From: Tim Shardlow [REDACTED]
Sent: 14 March 2022 21:04
To: Planning
Cc: Nick Addis; cllrjohnson@bourtons-cherwell-pc.gov.uk; Councillor George Reynolds; Councillor Phil Chapman; Councillor Douglas Webb; cropredypc.clerk@gmail.com; rchaf@aol.com; tony.brummel@cherwell-dc.gov.uk
Subject: FW: APPLICATION 22/00499/DISC THE STABLES MAIN STREET GREAT BOURTON OX17 1QU

APPLICATION 22/00499/DISC CONDITION 5
THE STABLES MAIN STREET GREAT BOURTON OX17 1QU APPEAL REF: APP/C/3105/C/21/3268454

# SITE LAYOUT PLAN

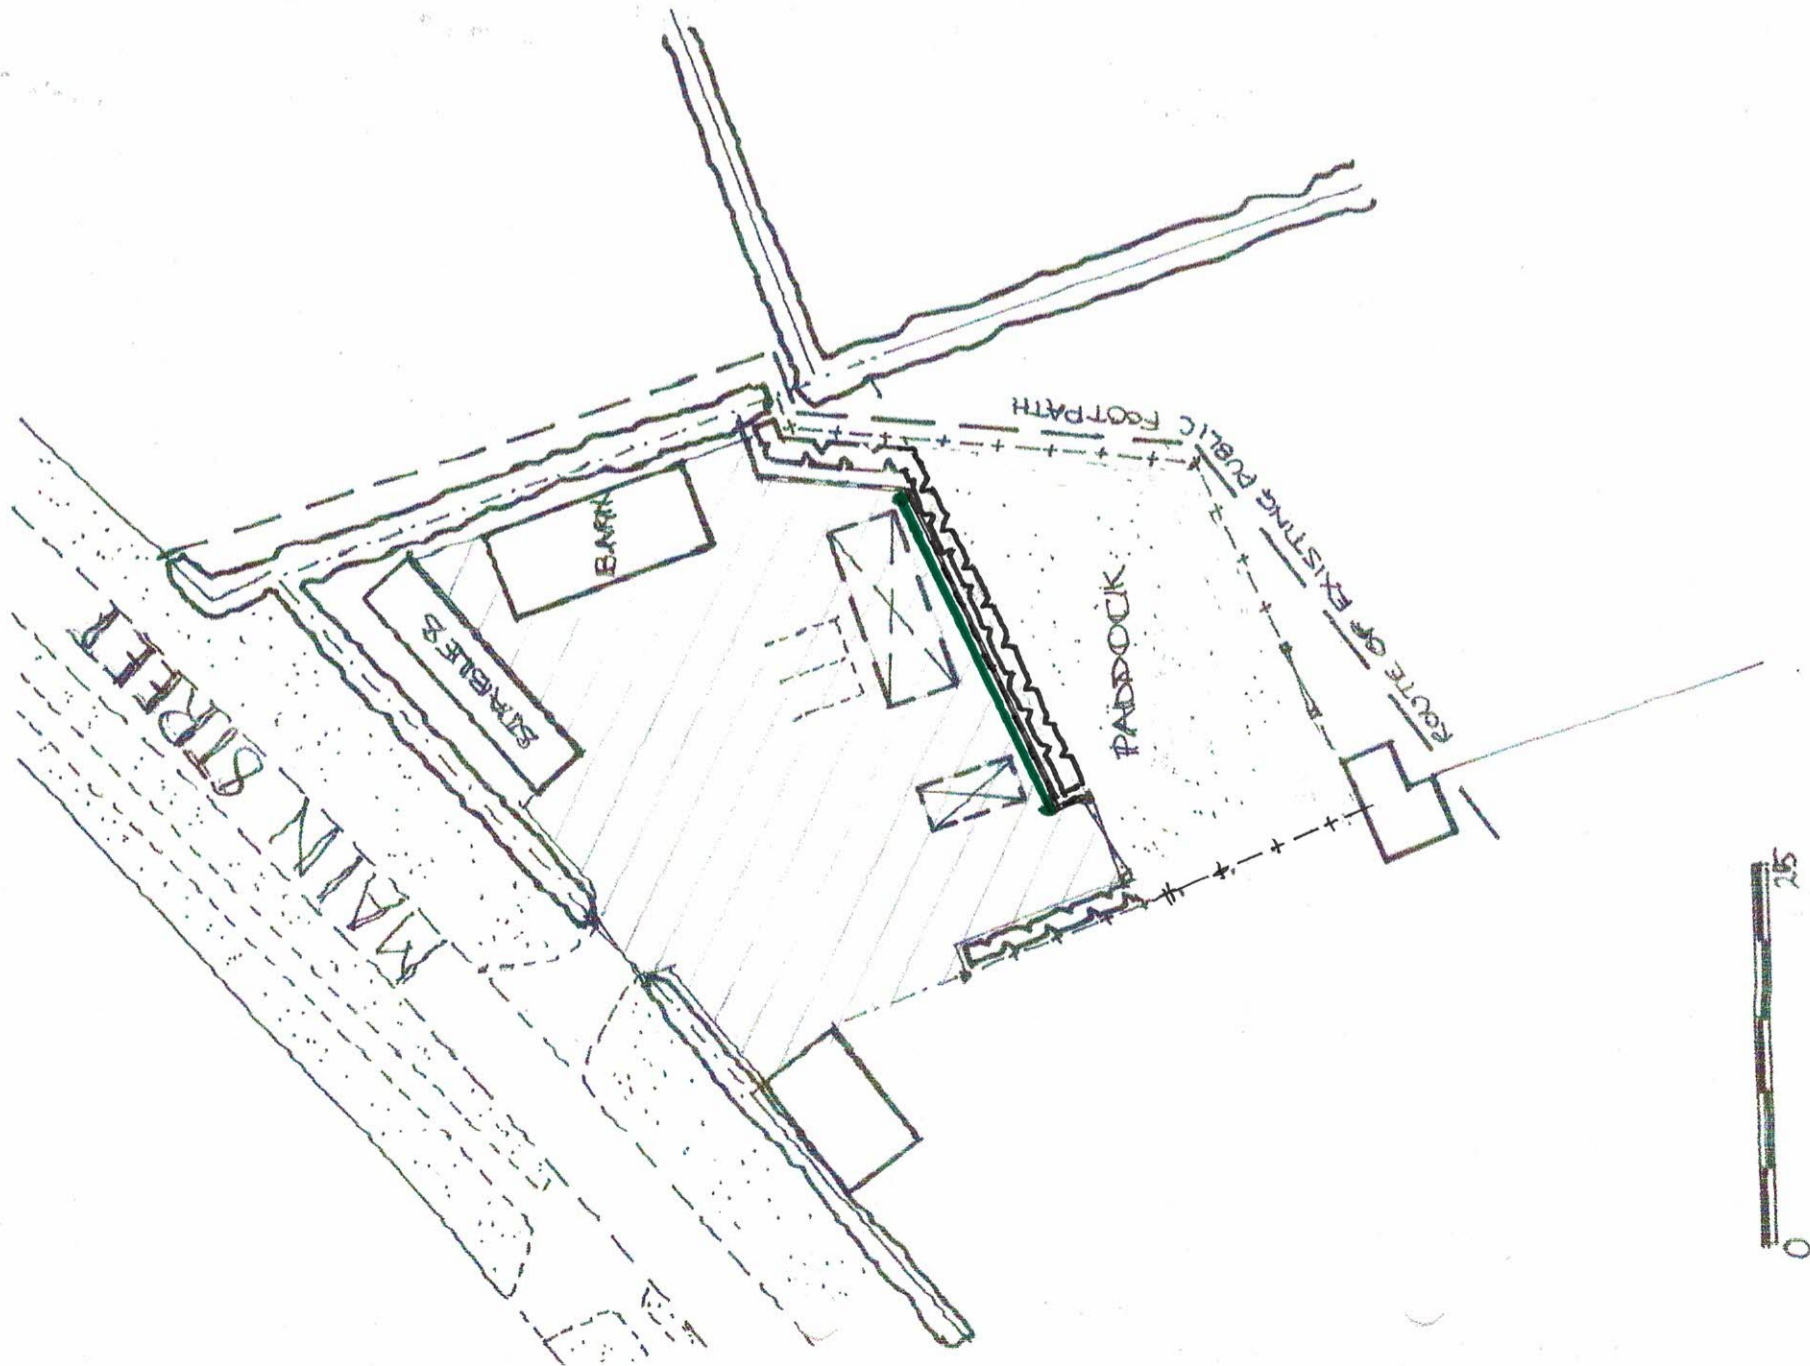
2. The area of hard standing recently installed will compromise further the drainage situation for the adjacent land. The area of hard standing should be removed.

3. The plan incorrectly plots the line of the public footpath.
4. The application form makes reference to the use of soakaways as previously accepted as part of a planning application for the adjacent Stables area. However I believe that the nature of the ground is such that soakaways are not a viable option in this location and thus use of soakaways should not be permitted. In addition the assertion that the only increase in impervious cover will be as a result from the caravans should not be relied on. We are very concerned that Mr Doran will want to use the site for considerably more caravans, once he has been able to establish a 'certificate of lawfulness' route to allow to further development. Any increase of run off into the drainage system has the potential to adversely affect the situation at the school at times of high rainfall. The school is in flood zone 3.

6. I note the use of '2m high timber screen fencing'. However this specification will not be sufficient to prevent further spoiling of the natural character of the valley by unsightly and inappropriate development of a non-agricultural nature.
